A303 Sparkford to Ilchester Dualling Scheme TR010036

8.17 Statement of Common Ground with Wessex Water

STATEMENT OF COMMON GROUND

Version	Date	Status of Version
A	March 2019	Draft submission for deadline 4

A303 SPARKFORD TO ILCHESTER DUALLING
WORKS PLANS REGULATION 5(2)(J)
SHEET 2 OF 4

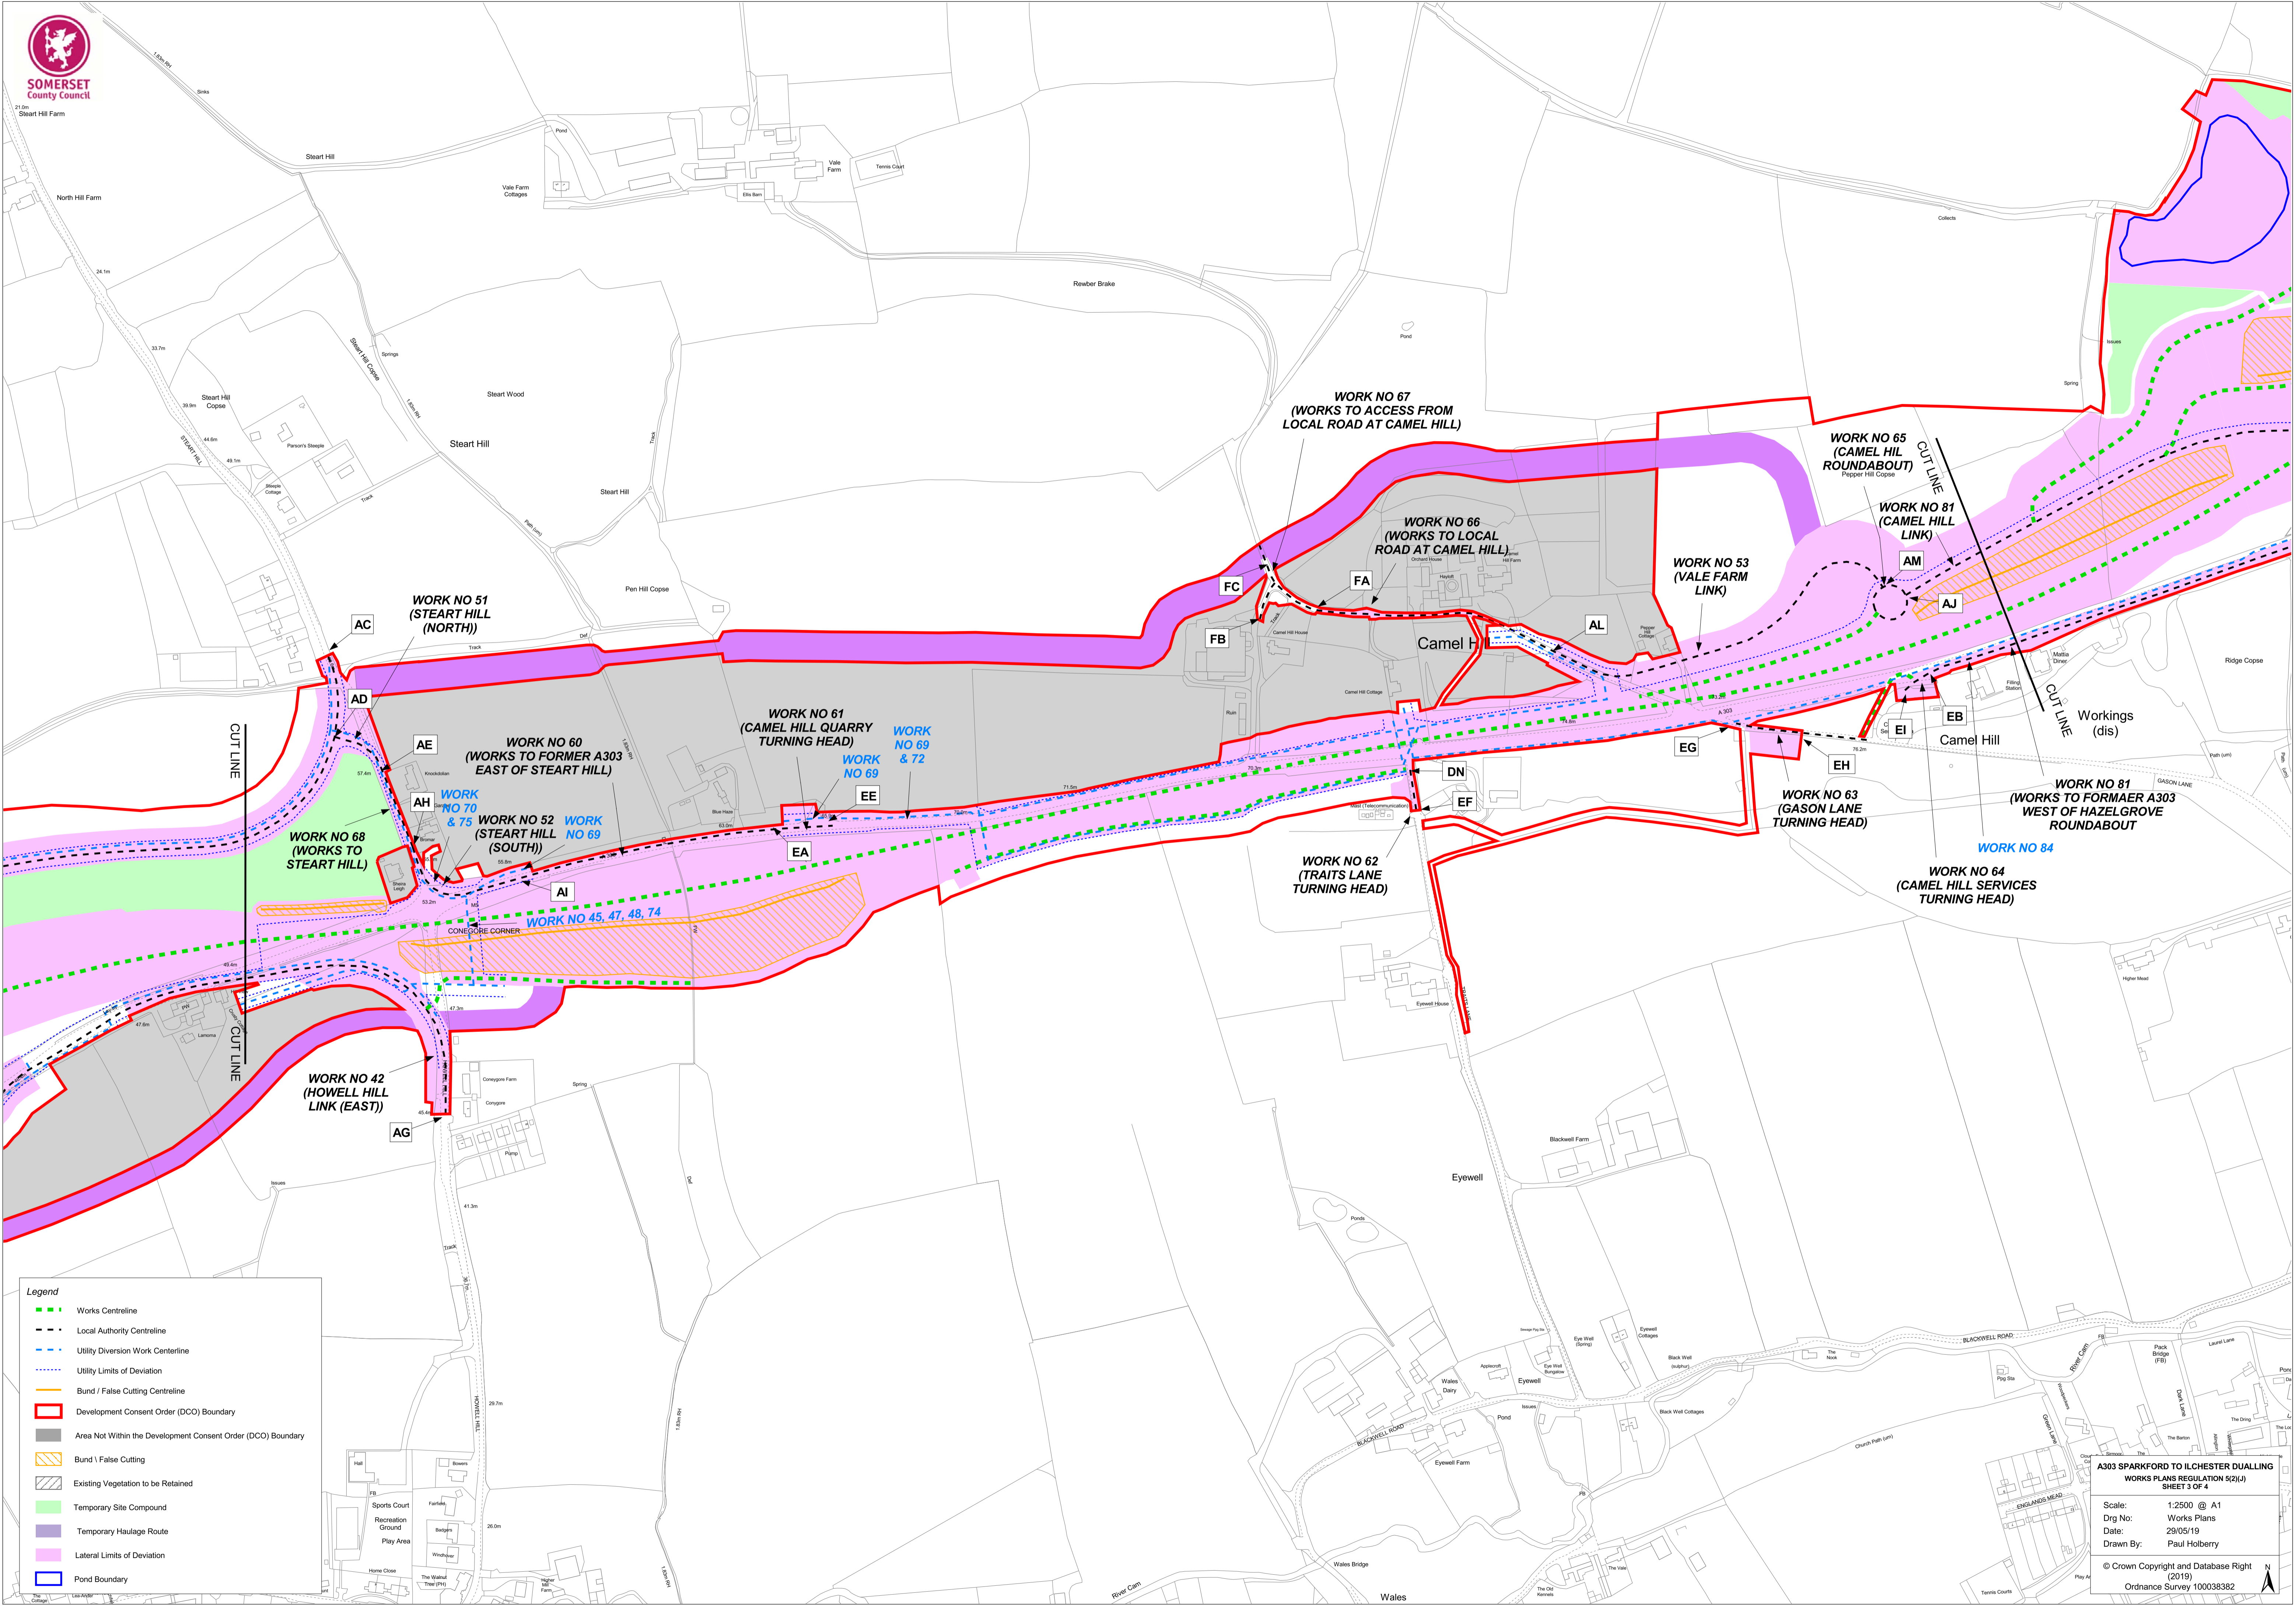
Topic	Sub-section	Wessex Water comment	Highways England response	Status
Mitigation of the effects of the project on the transmission/distribution systems	Sch 1. Work No.32 – The diversion of 500 metres of water distribution apparatus, shown on sheet 2 of the Works Plans between points JD and JJ.	Appears acceptable subject to notes below.	Noted	AGREED
	Sch 1.Work No.44 – The diversion of 1470 metres of water supply apparatus, shown on sheets 2 and 3 of the Works Plans between points JR, JS, JN, JO and KA.	Appears acceptable subject to notes below.	Noted	AGREED
	Sch. 1 Work No.46 – The diversion of 250 metres of water distribution apparatus, shown on sheets 2 and 3 of the Works Plans between points JU and JX.	Appears acceptable subject to notes below.	Noted	AGREED
	Sch. 1 Work No.68 – Works to the existing 'Stear Hill', shown on sheet 3 of the Works Plans between points EA and AH. To include: (a) Installation of surface water	There are water mains and sewers at this location. The water main here is being abandoned subsequent to works 44 & 46.	Noted	UNDER DISCUSSION

A303 SPARKFORD TO ILCHESTER DUALLING
WORKS PLANS REGULATION 5(2)(J)
SHEET 3 OF 4

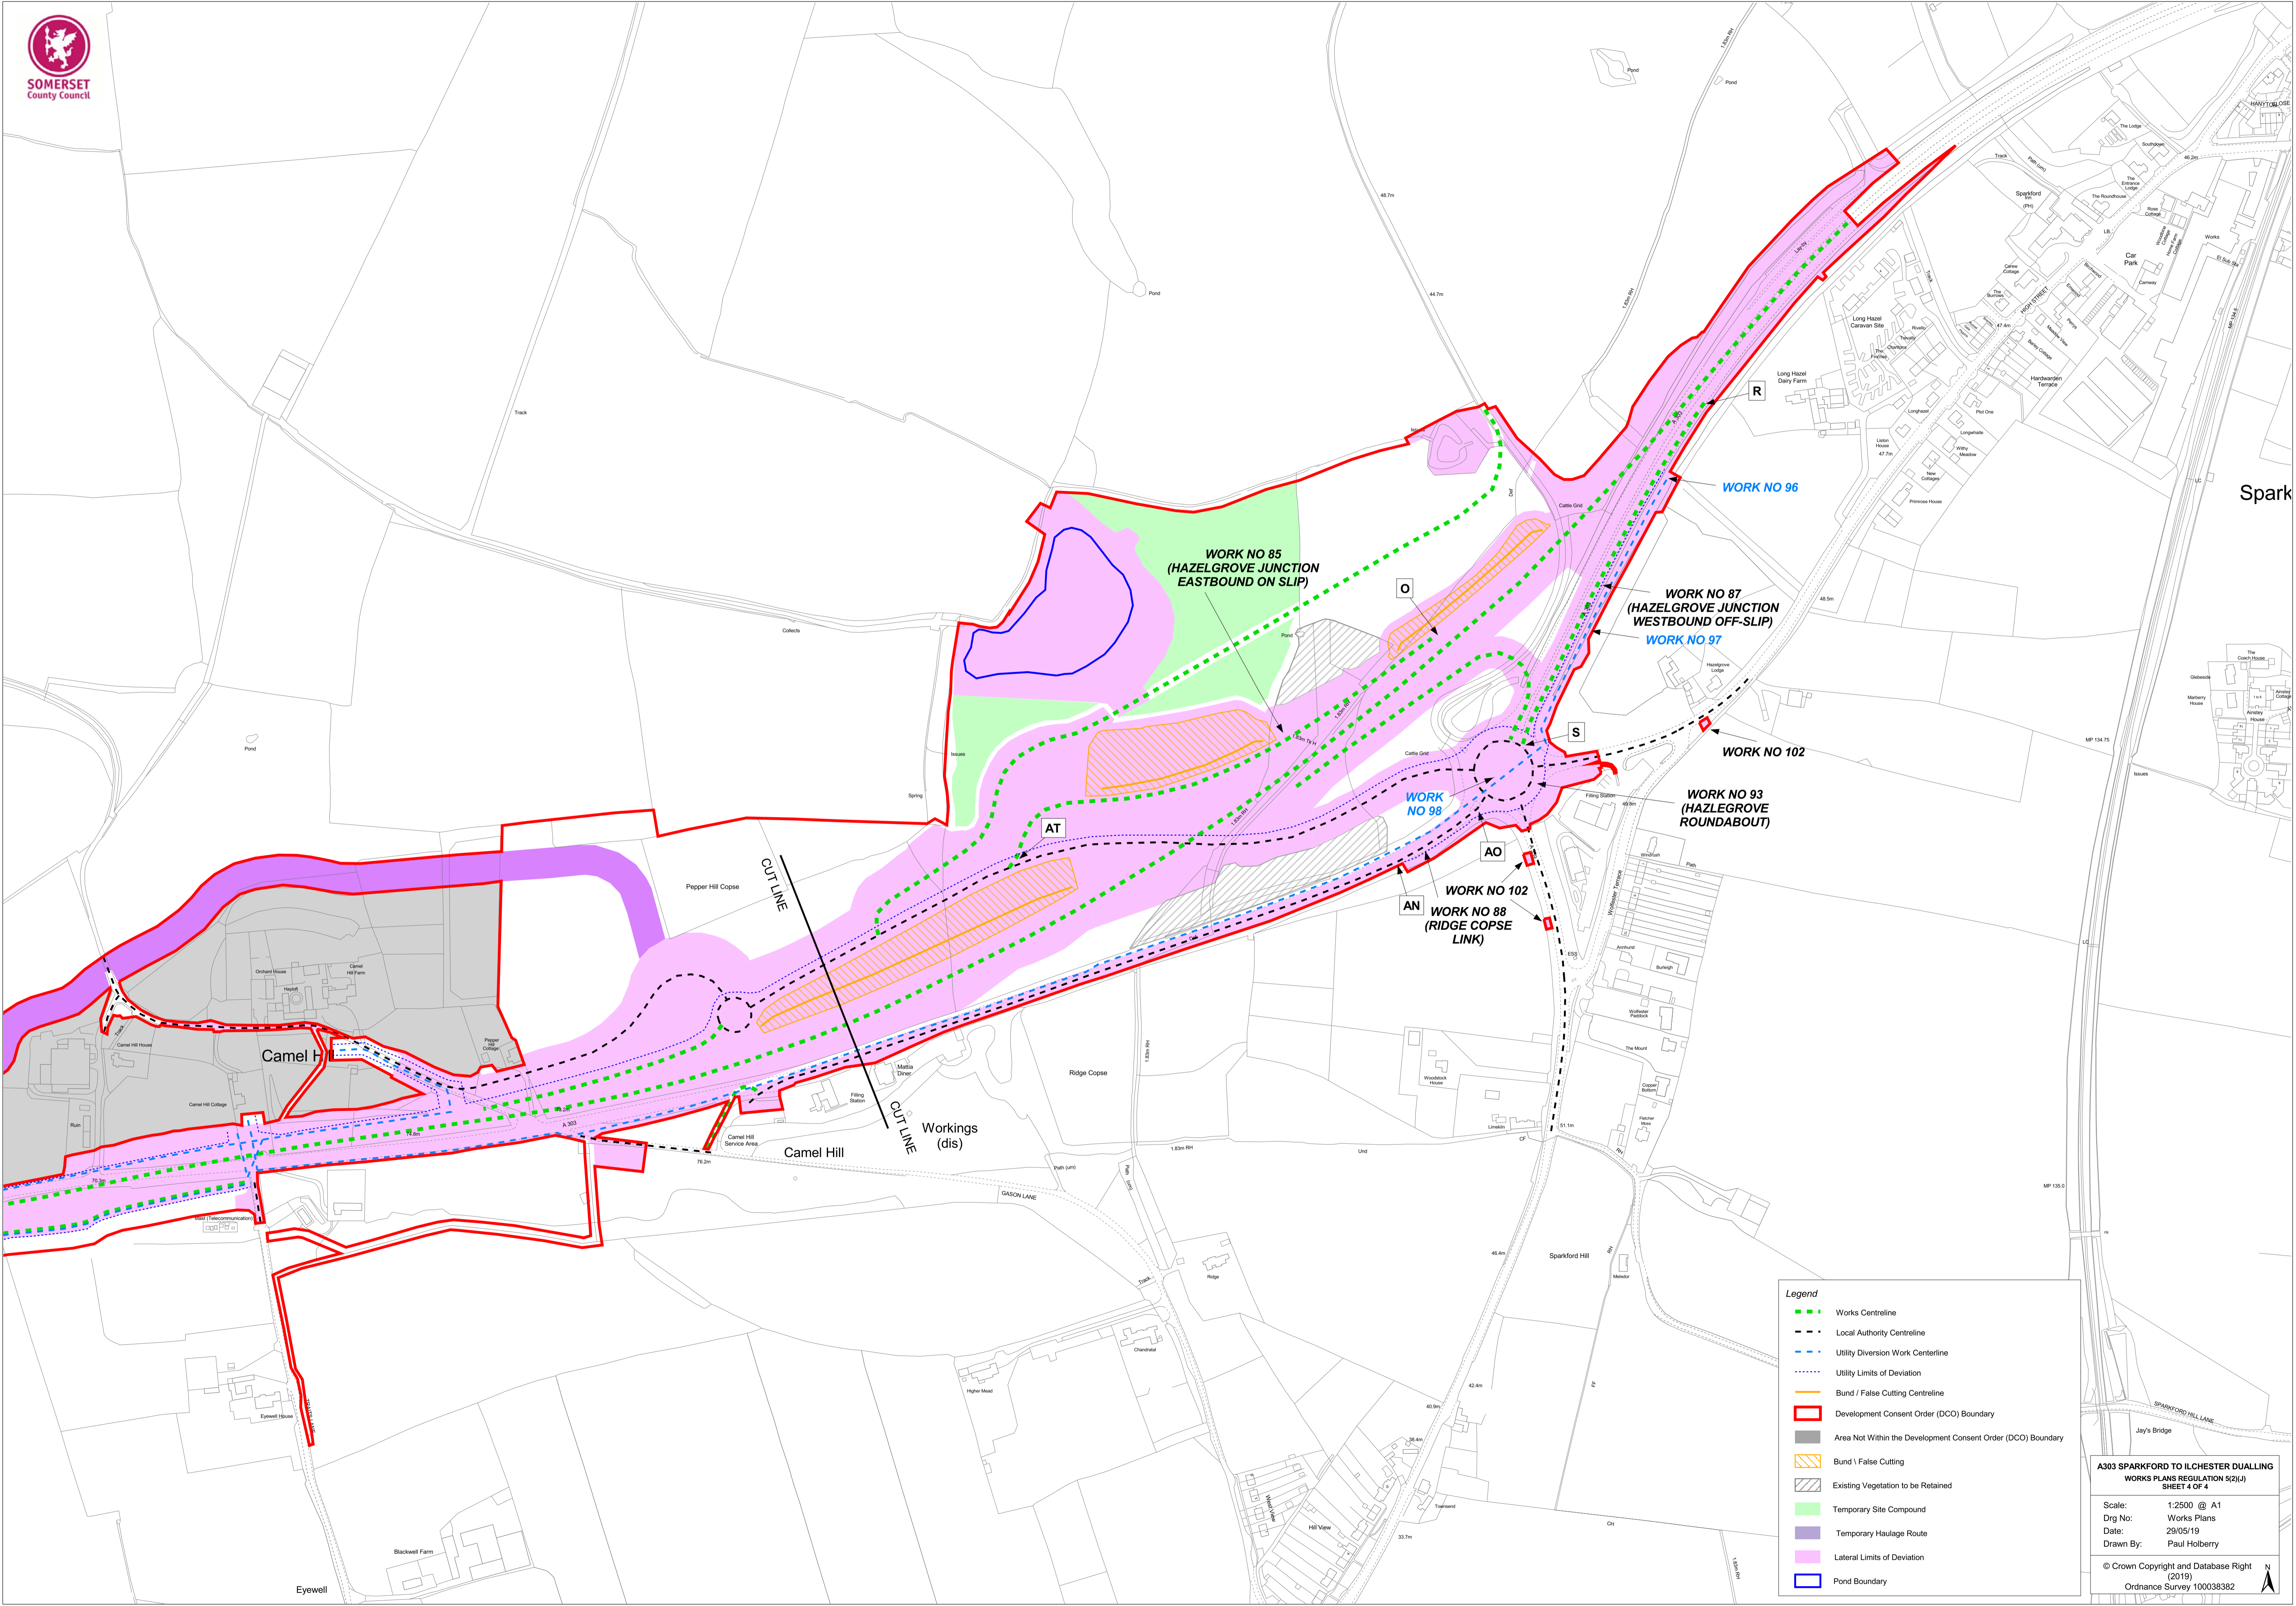
Topic	Sub-section	Wessex Water comment	Highways England response	Status
	drainage. (b) Utilities diversions.			
	Sch. 1 Work No.74 – The diversion of 320 metres of public sewer, shown on sheet 3 of the Works Plans between points JX and KP.	Agreement will need to be made as to the relocation of existing manholes, maintaining suitable cover levels and dualling the sewer to lessen the risk of Highway works in the future.	Agreed. It is anticipated that Highways England will design and construct this sewer diversion in accordance with the Specifications in Sewers for Adoption. Design will take place in the second half of 2019 and Wessex Water will be consulted during this process.	UNDER DISCUSSION
	Sch. 1 Work No.77 – The diversion of 50 metres of water distribution apparatus, shown on sheet 3 of the Works Plans between points KH and KI.	Mains level to be altered with the road and contained within a duct. Twinned ducts preferred to ensure security of supply and lessen the risk of Highway works in the future. Specifications to be agreed and subject to the notes below.	Agreed. Detail design will take place in the second half of 2019 and Highways England will request a detailed design and specification for this and all other works to Wessex Water's distribution system in accordance with the procedure set out in Appendix C4 of the code of practice "Measures necessary where apparatus is affected by major works (diversionary works)".	UNDER DISCUSSION
